REQUEST

Current Zoning: R-4 (single family residential)
Proposed Zoning: R-12MF(CD) (multi-family residential, conditional)

Approximately 4.2 acres located on the south side of Lakeview Road, west of Reames Road, and east of Beatties Ford Road.

The petition proposes a residential community of up to 41 single family attached dwelling units on vacant land.

RZ.01

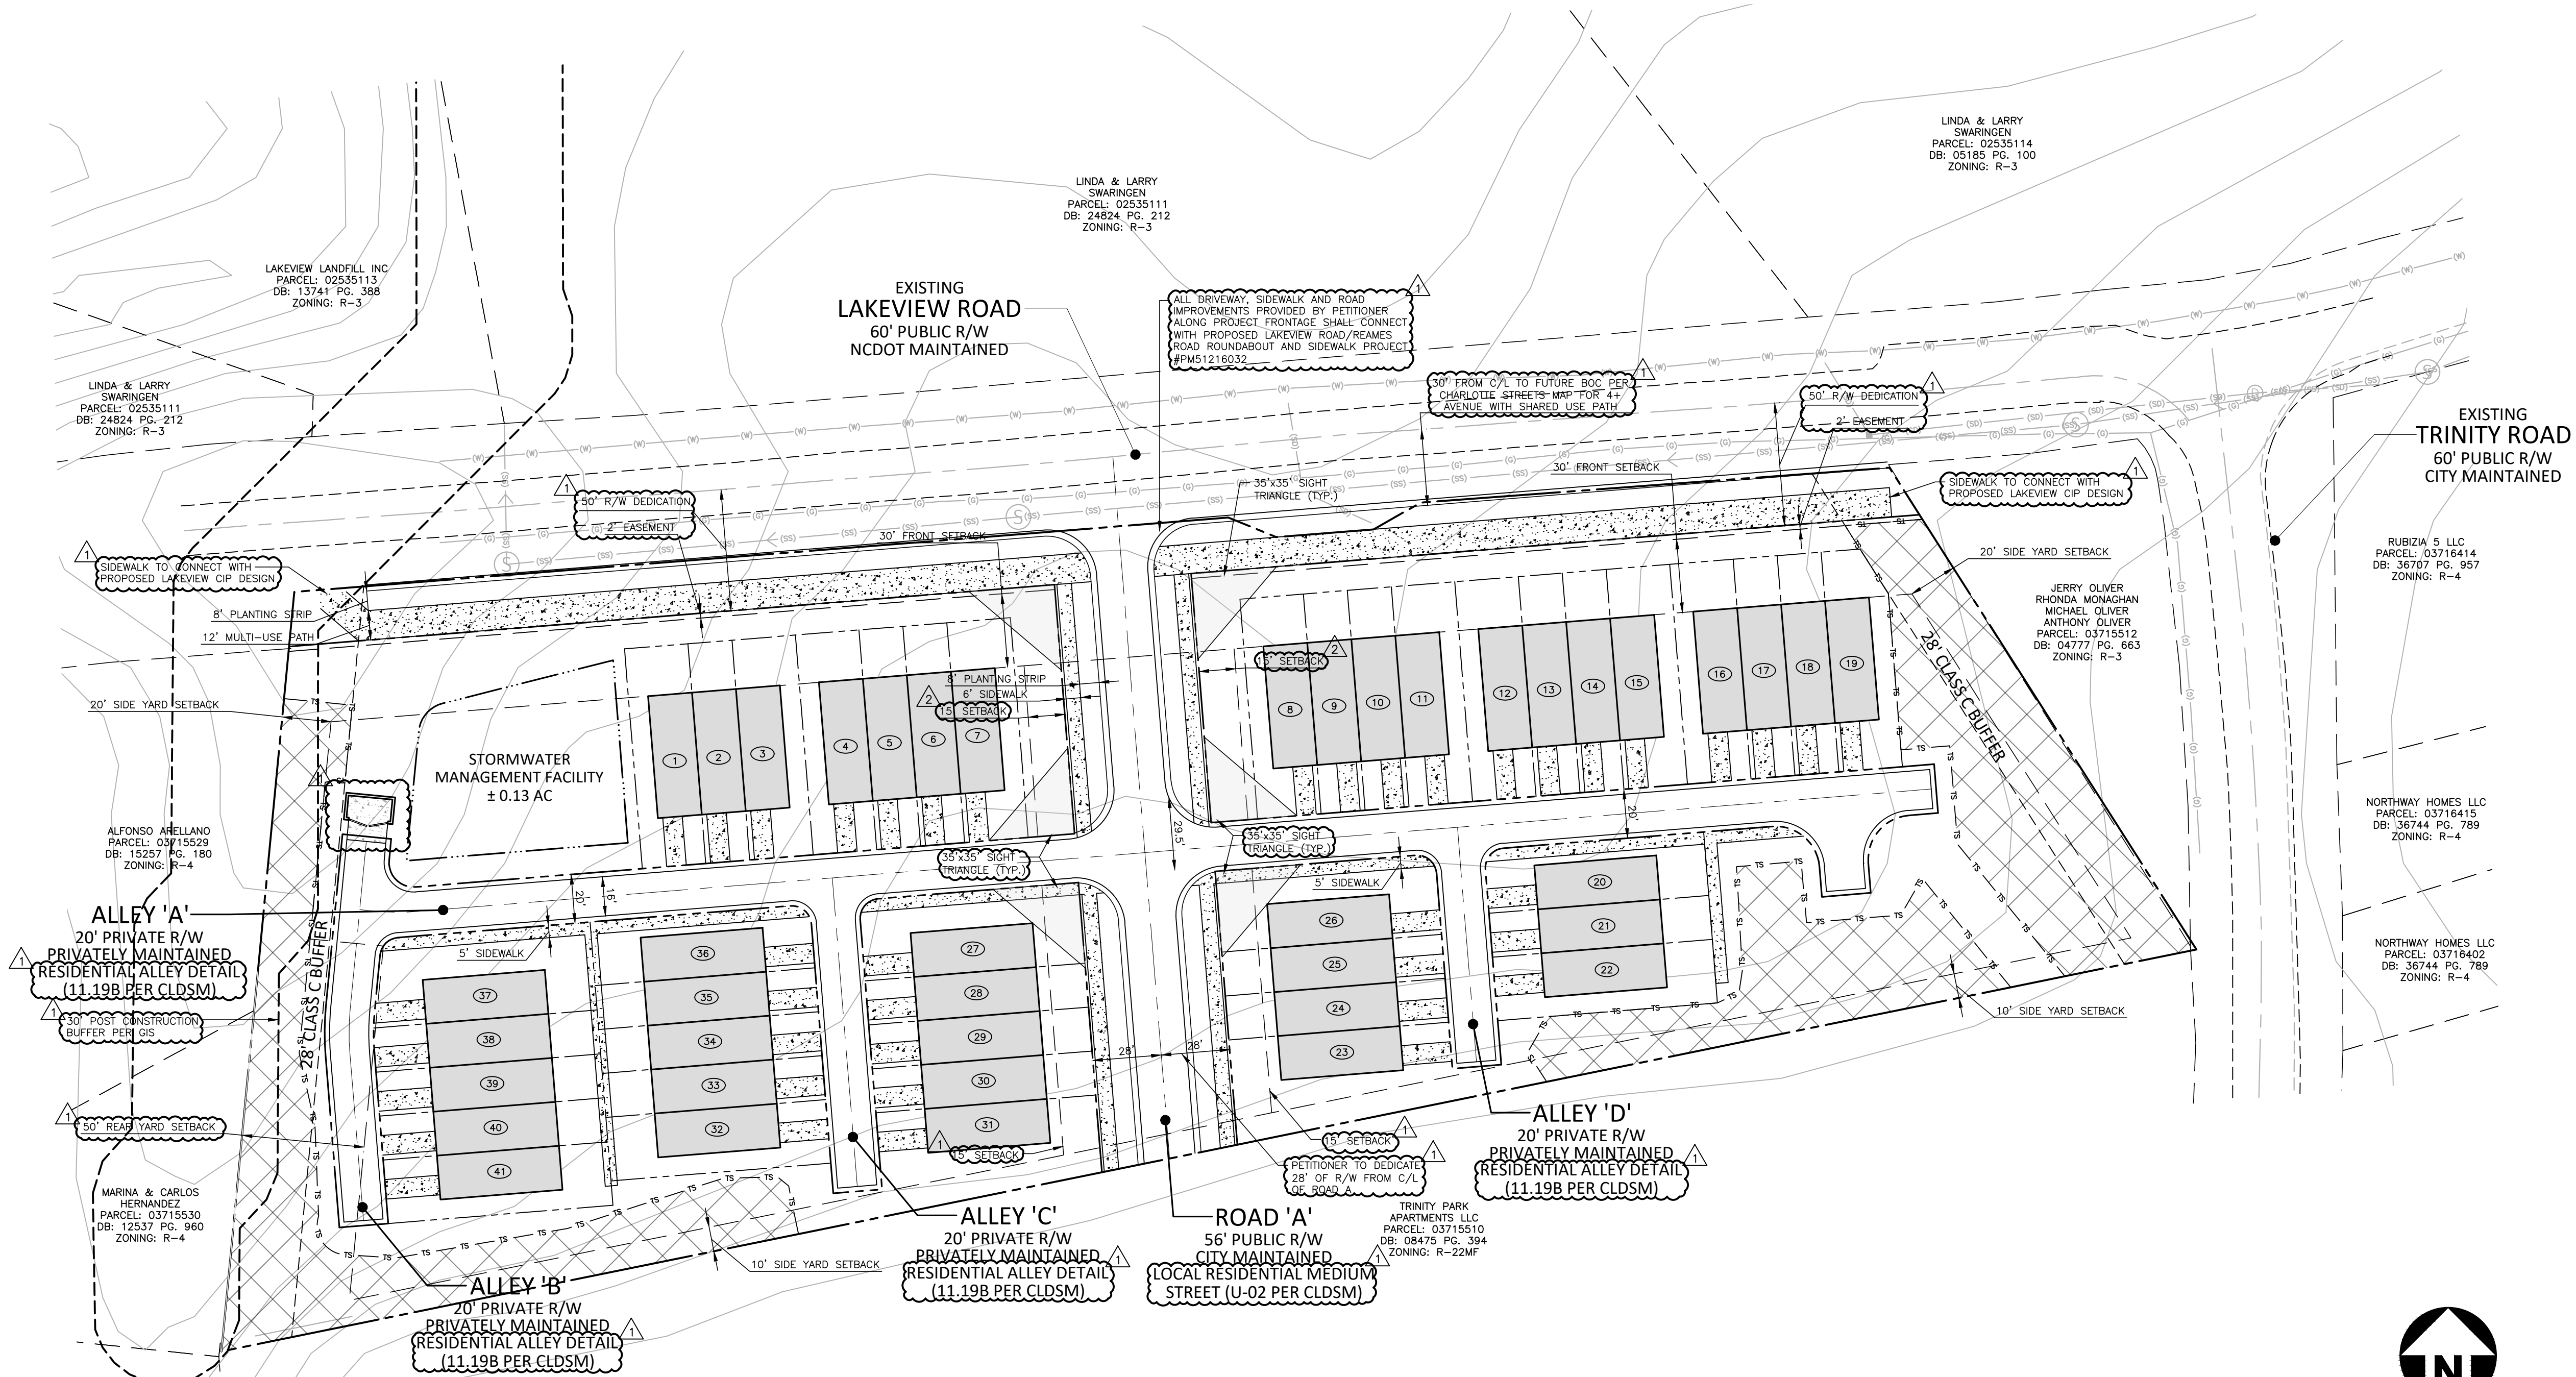
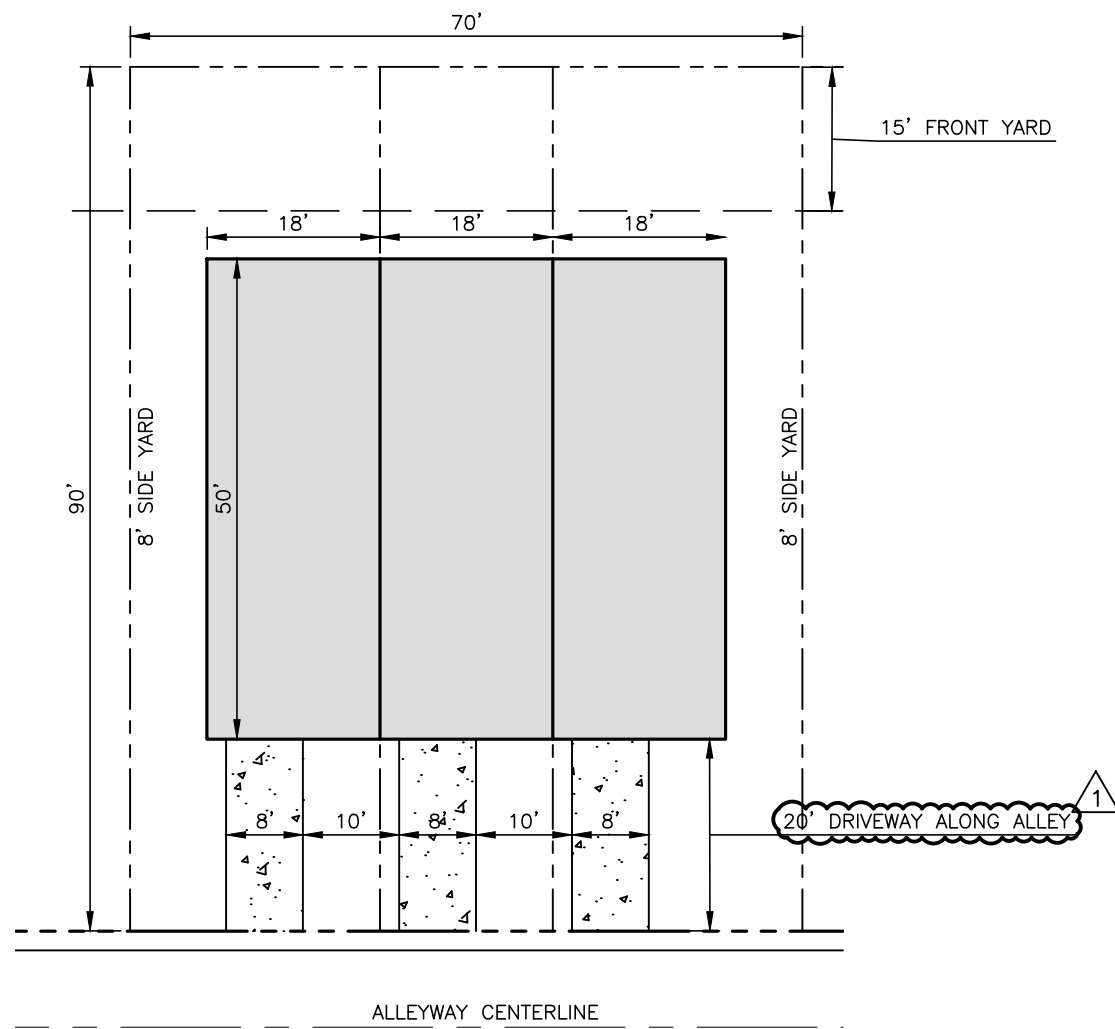
- ~~1. Add a conditional note specifying "A Right-of-Way Encroachment Agreement is required for the installation of any non-standard item(s) (irrigation systems, decorative concrete pavement, brick pavers, etc.) within a proposed/existing City-maintained street right-of-way by a private individual, group, business, or homeowner's/business association. An encroachment agreement must be approved by CDOT prior to construction/installation. Contact CDOT for additional information concerning cost, submittal, and liability insurance coverage requirements."~~ Addressed
2. Driveways will be required to be moved out of sight triangles. Addressed
